## **Application No: SSD 13\_6123**

Campus Improvement Program 2014-2020 for Camperdown-Darlington

RAIDD Response to RtS for SSD6123

**Date:** 25 August 2014

01 ENGINEERING - SHEPHERD STREET ELEVATION PROPOSED

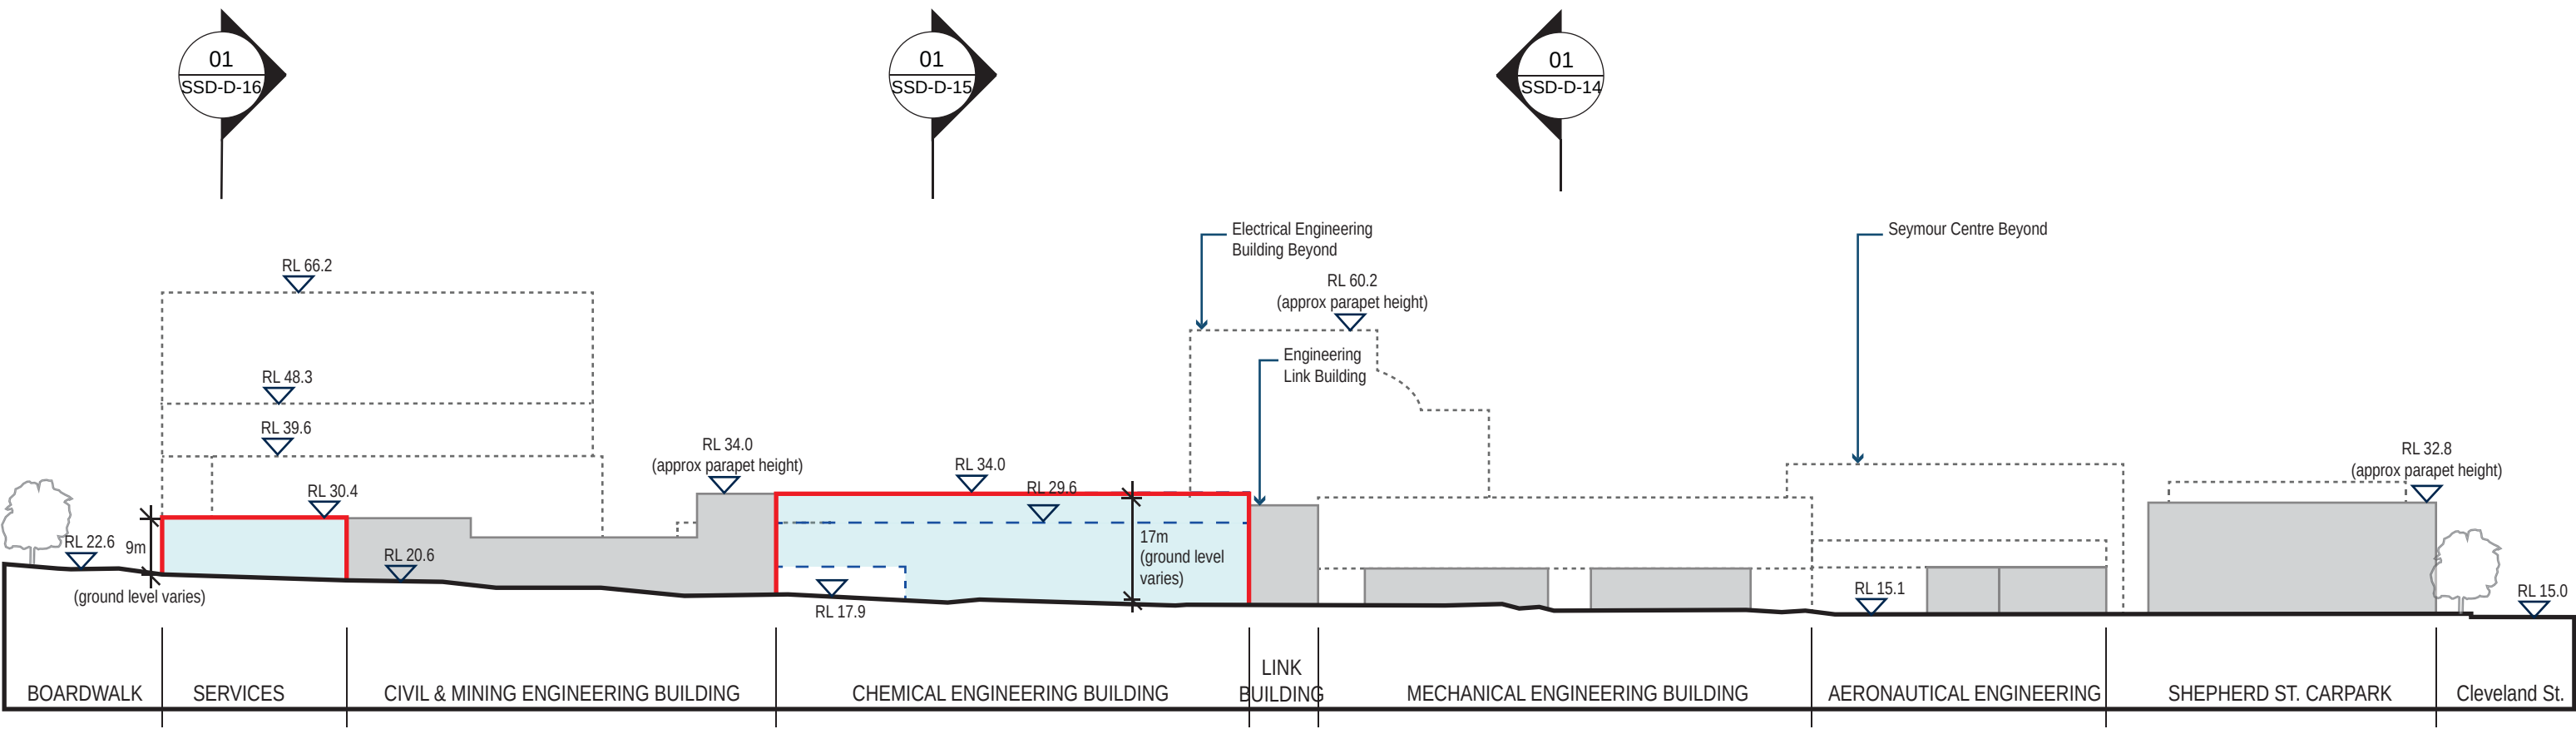
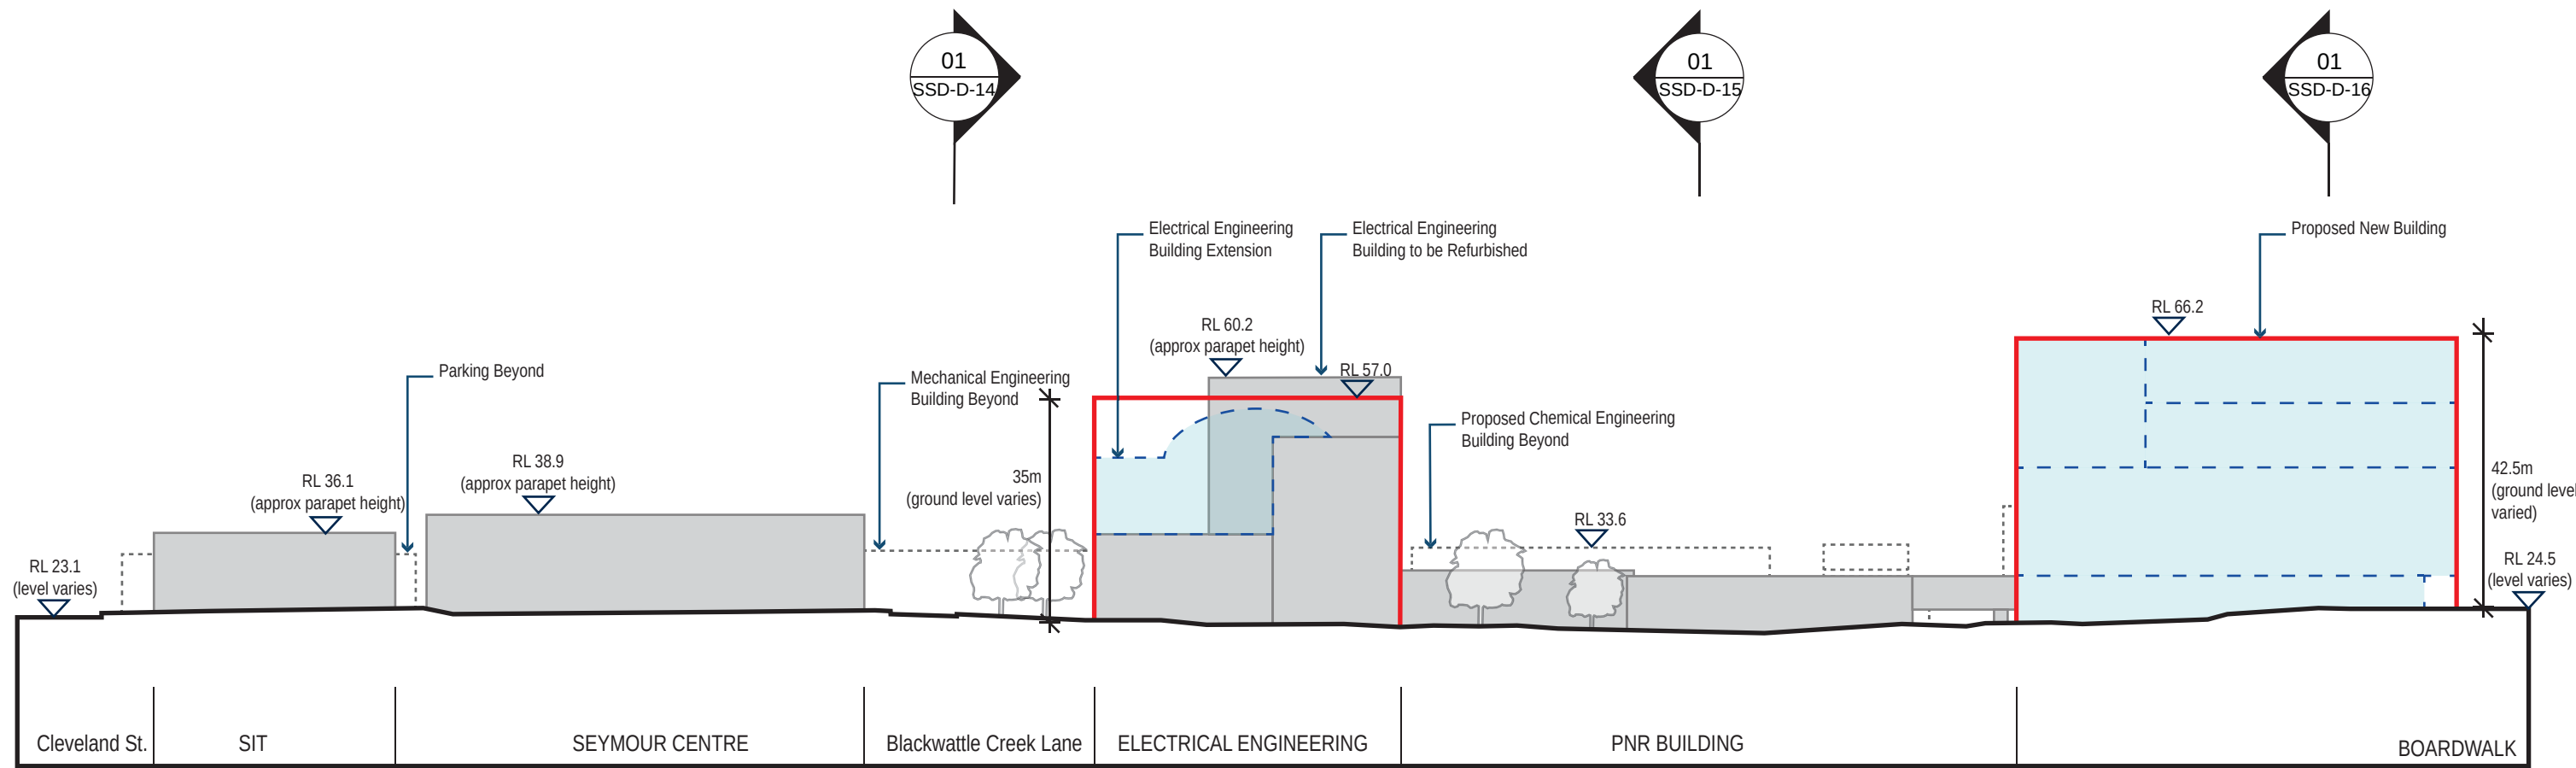
We remain opposed to the proposed Service Centre on Shepherd Street. We understand the rationale behind having principal Service Centres but repeat our suggestion that a more appropriate location for it would be near the intersection of Shepherd and Cleveland Streets.

This would mean the heavy service vehicles could enter and exit from the main arterial road of Cleveland Street and would therefore be kept off residential streets.

01 DARLINGTON TERRACES - PROPOSED ENVELOPE PLAN

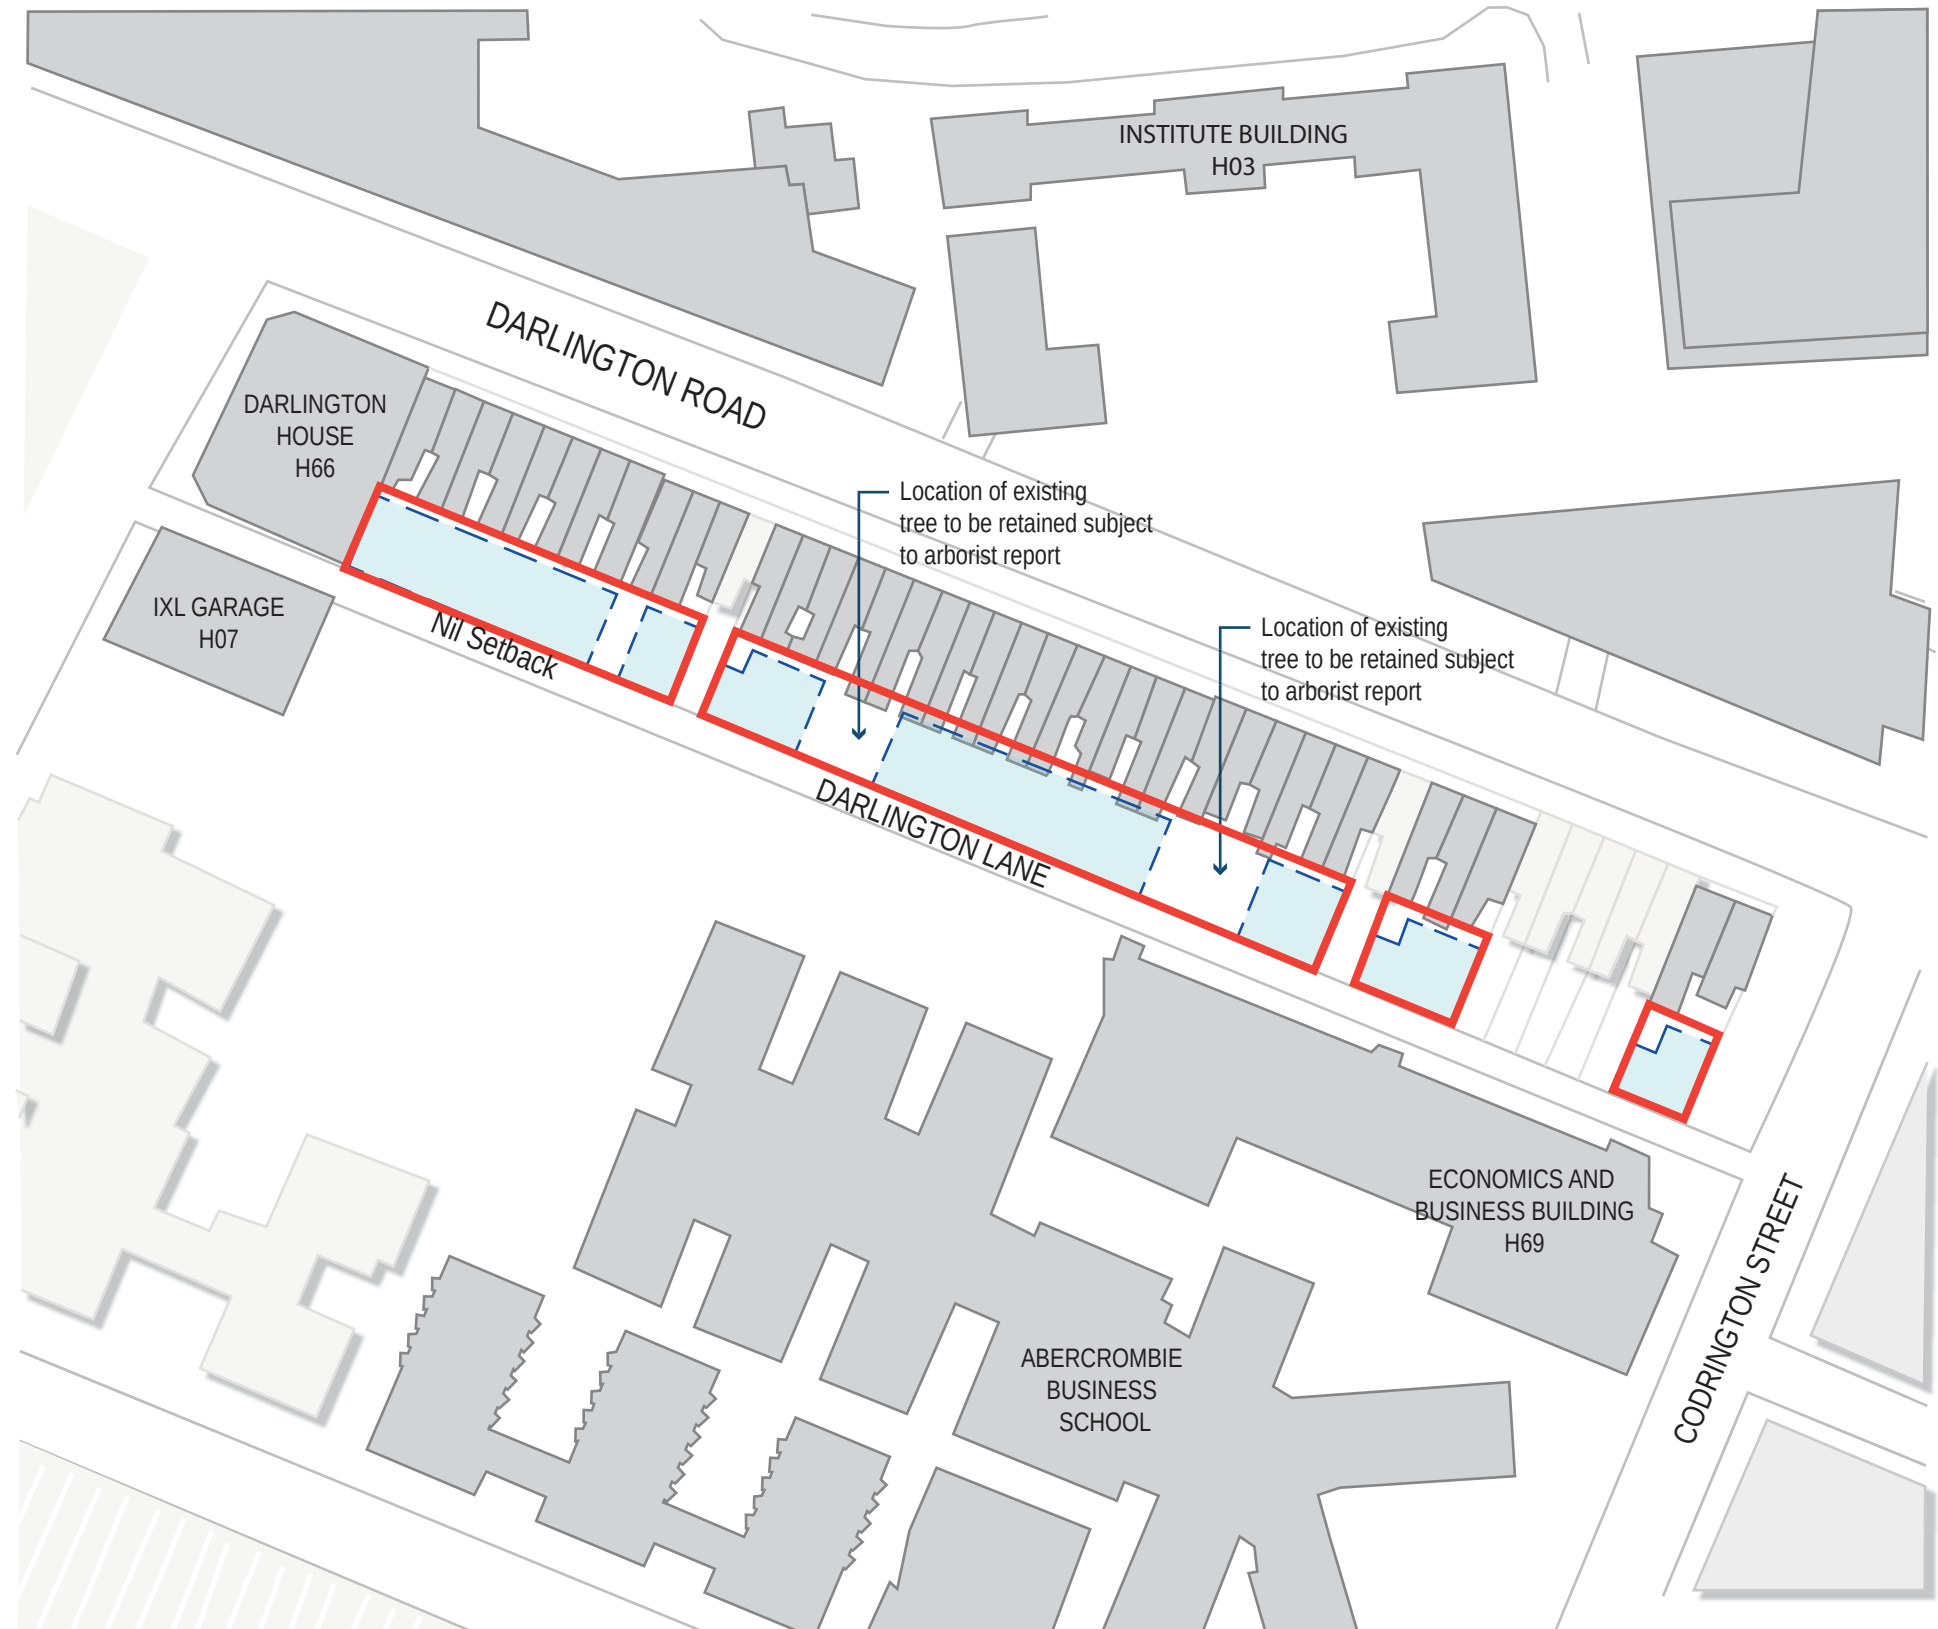
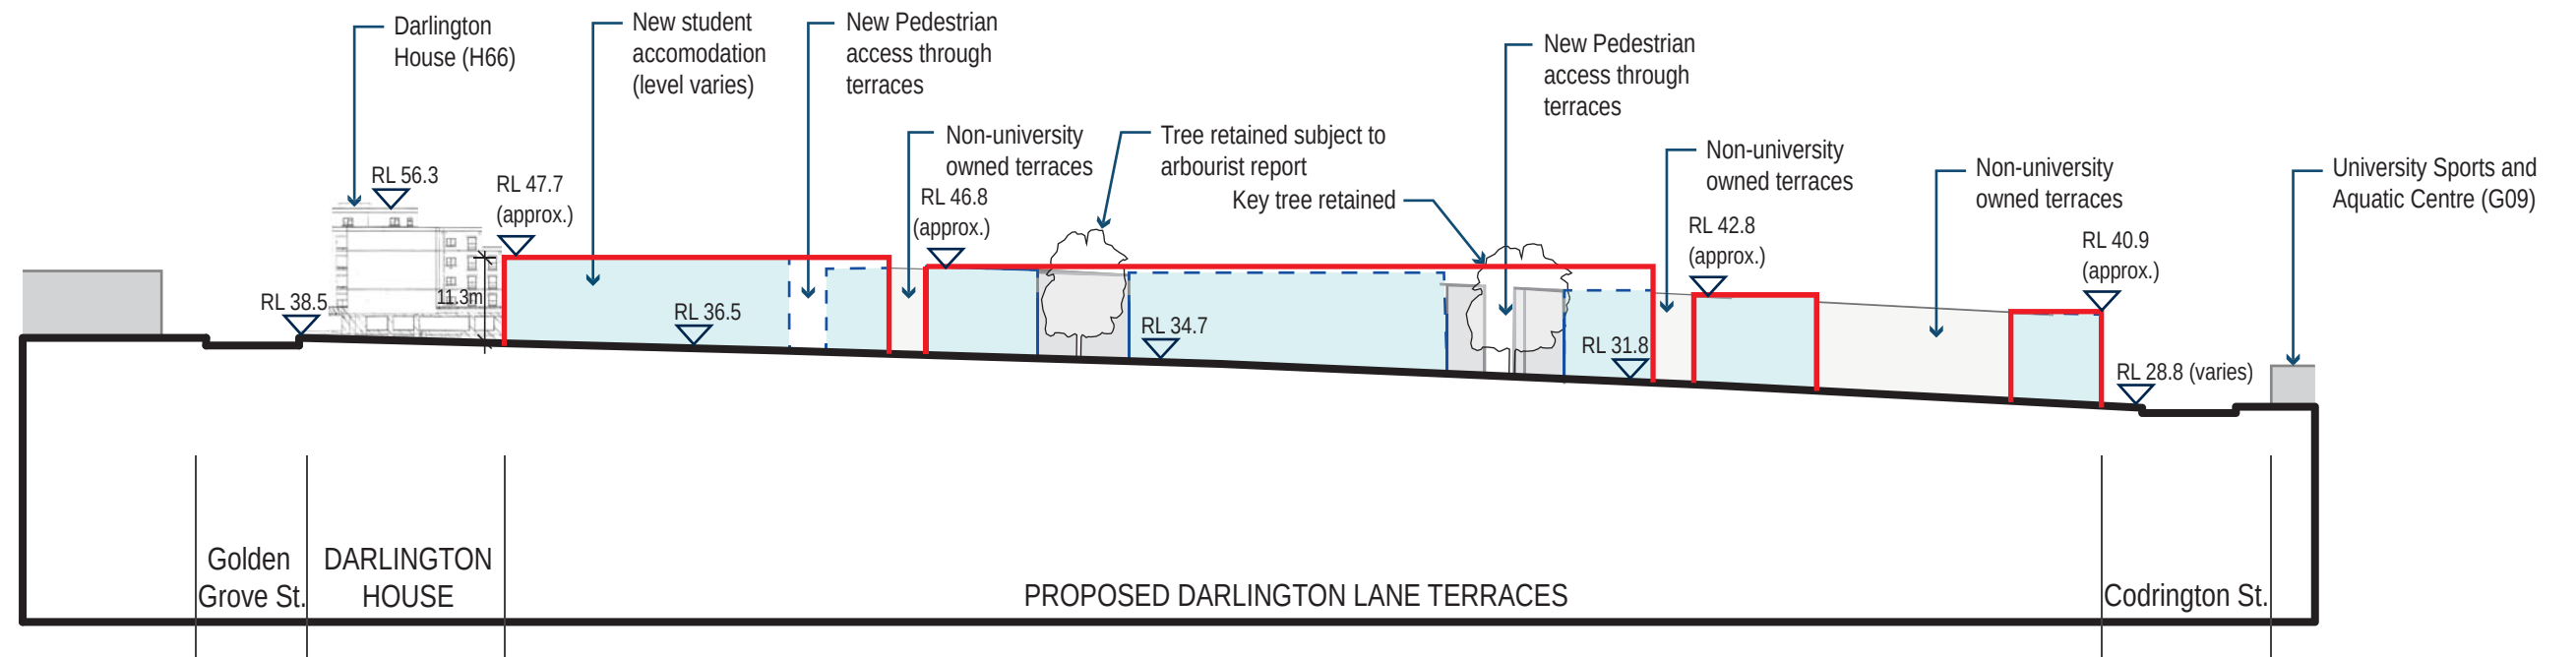
We vehemently object to the University's proposal to completely infill the backyards of every heritage listed terrace house (bar 3) from 86 – 130 Darlington Road with 3 storey extensions. The University will have used almost every piece of land for building on leaving very little open space, vegetation or light which are all important to the health and wellbeing of humans.

The National Trust has given these terraces an "A" rating – "highly intact". The University should not be allowed to degrade the heritage value of these terraces which are very close to the Golden Grove.
